From: [REDACTED]
Sent: 27 July 2013 10:03
To: Charlotte Burrows
Cc: Planning
Subject: 9 Cunningham Gardens Felpham. PO22 7QP

From: brian hindle [REDACTED]
Sent: 30 July 2013 19:53
To: Charlotte Burrows
Subject: RE: FP/124/13/ - 9 Cunningham Gardens, Felpham
Attachments: cunningham site plan.pdf

From: Charlotte.Burrows@arun.gov.uk
To: [REDACTED]
Subject: FP/124/13/ - 9 Cunningham Gardens, Felpham
Date: Tue, 30 Jul 2013 11:08:07 +0000

part proposed floor plan.

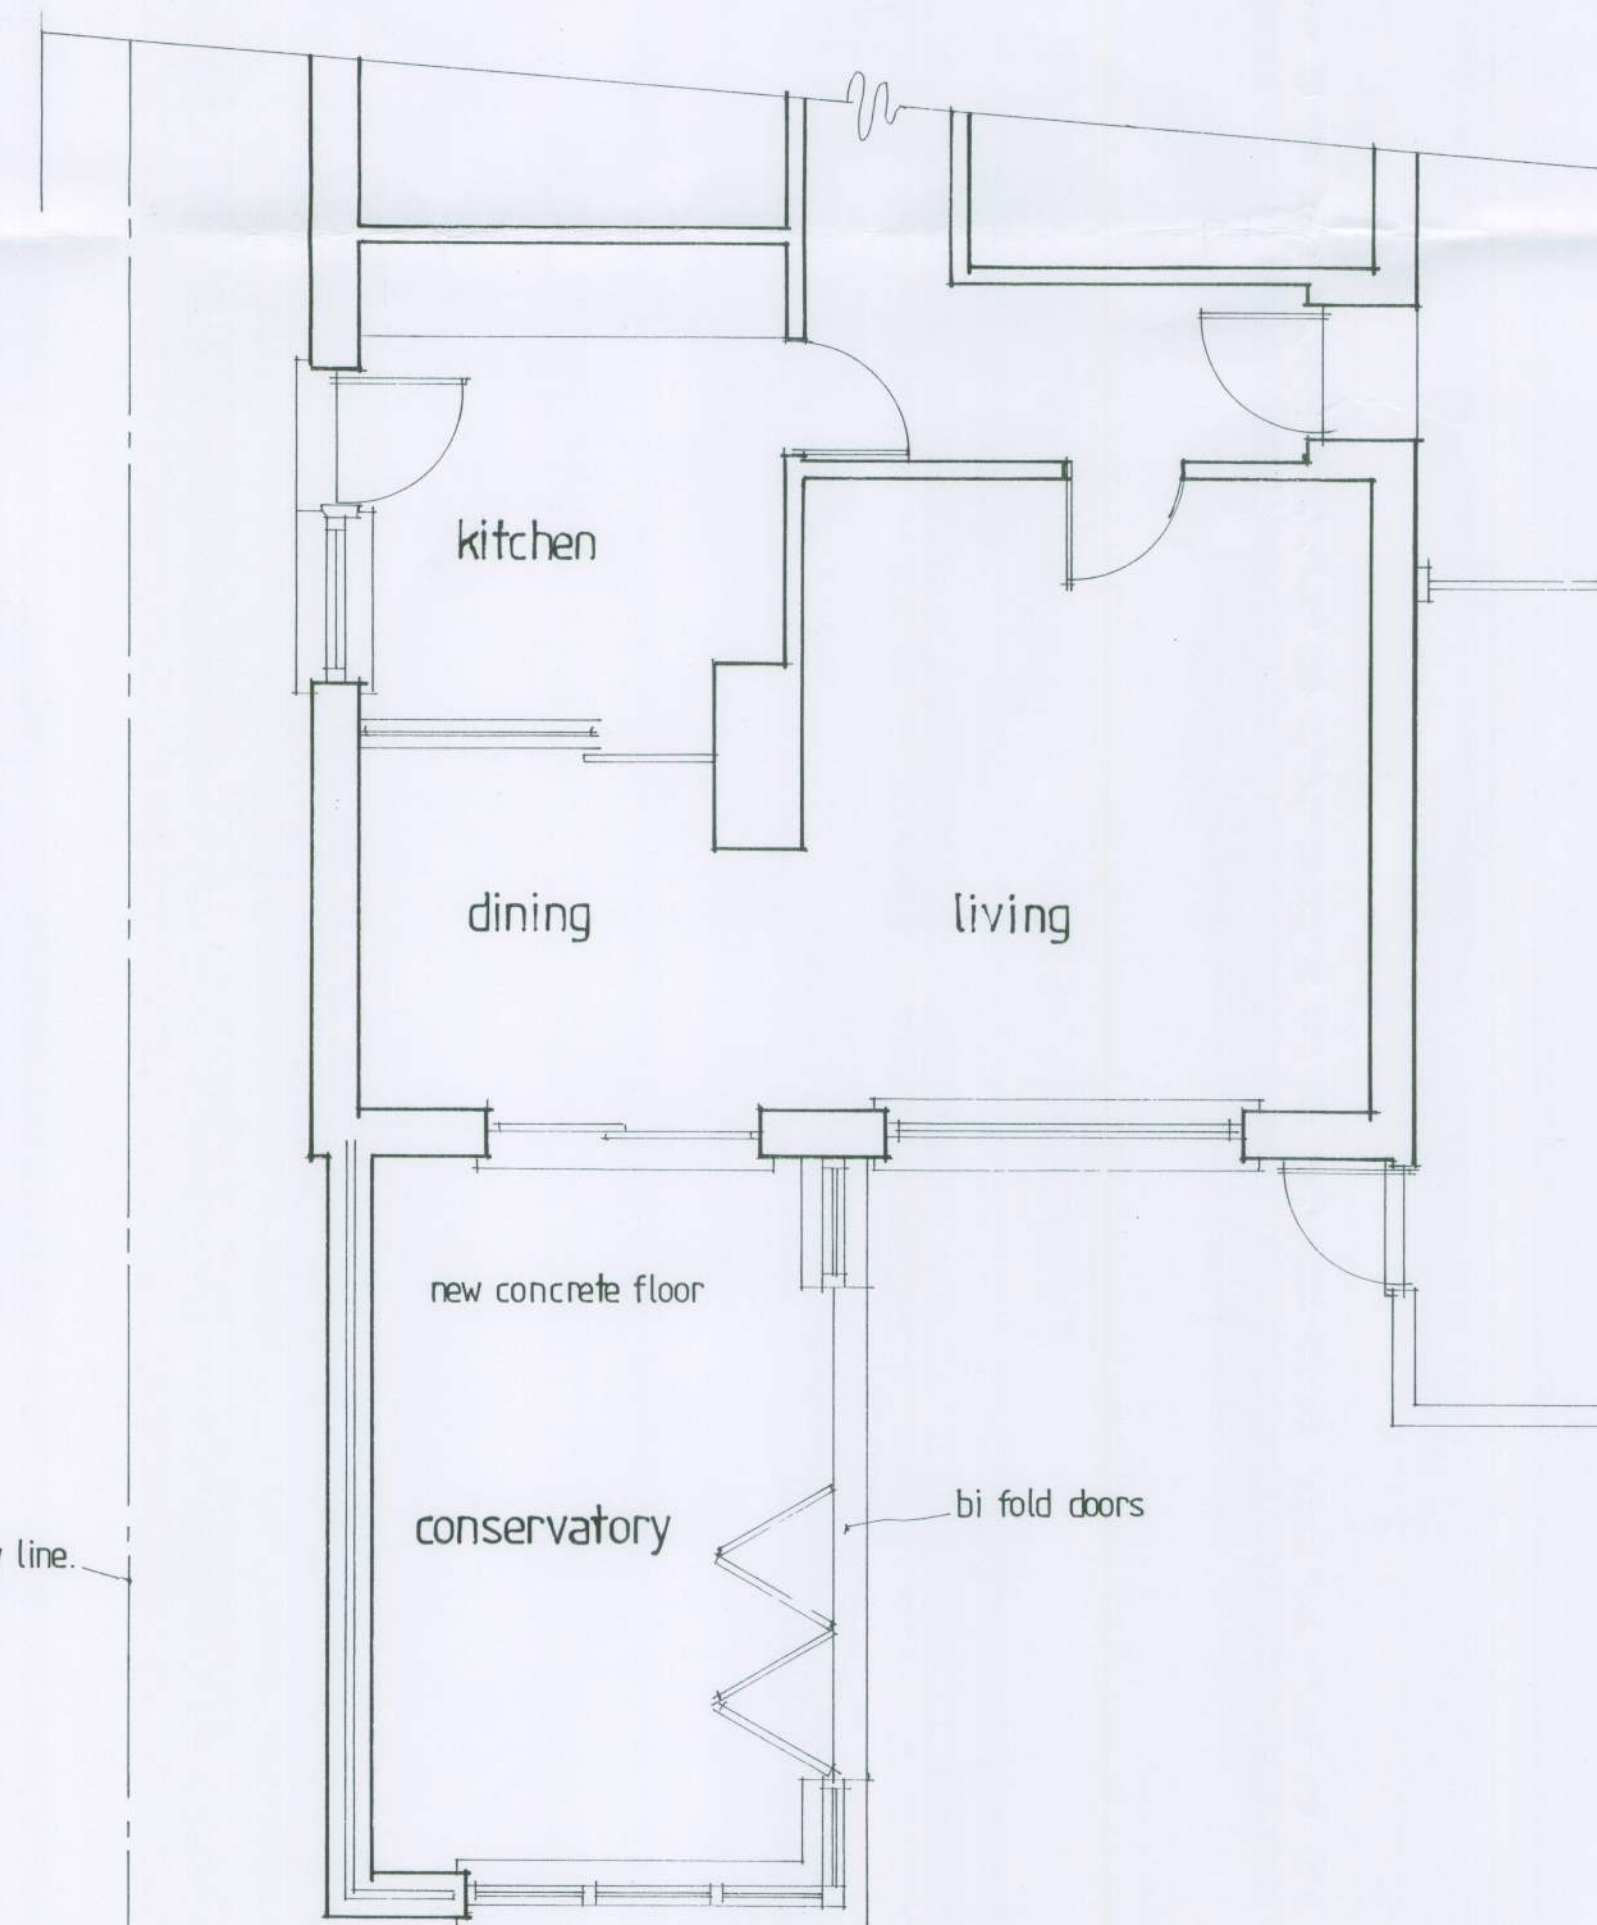
Thank you for sending in the amended Block plan, unfortunately I require a few more boundaries measurements, I need you to indicate the measurements from the rear of the proposed conservatory to the garden boundary and the distance between the side of the proposed conservatory to the garden boundary.

Please find enclosed attached file with additional dimensions as requested. I trust this is now satisfactory and the application can now be registered.
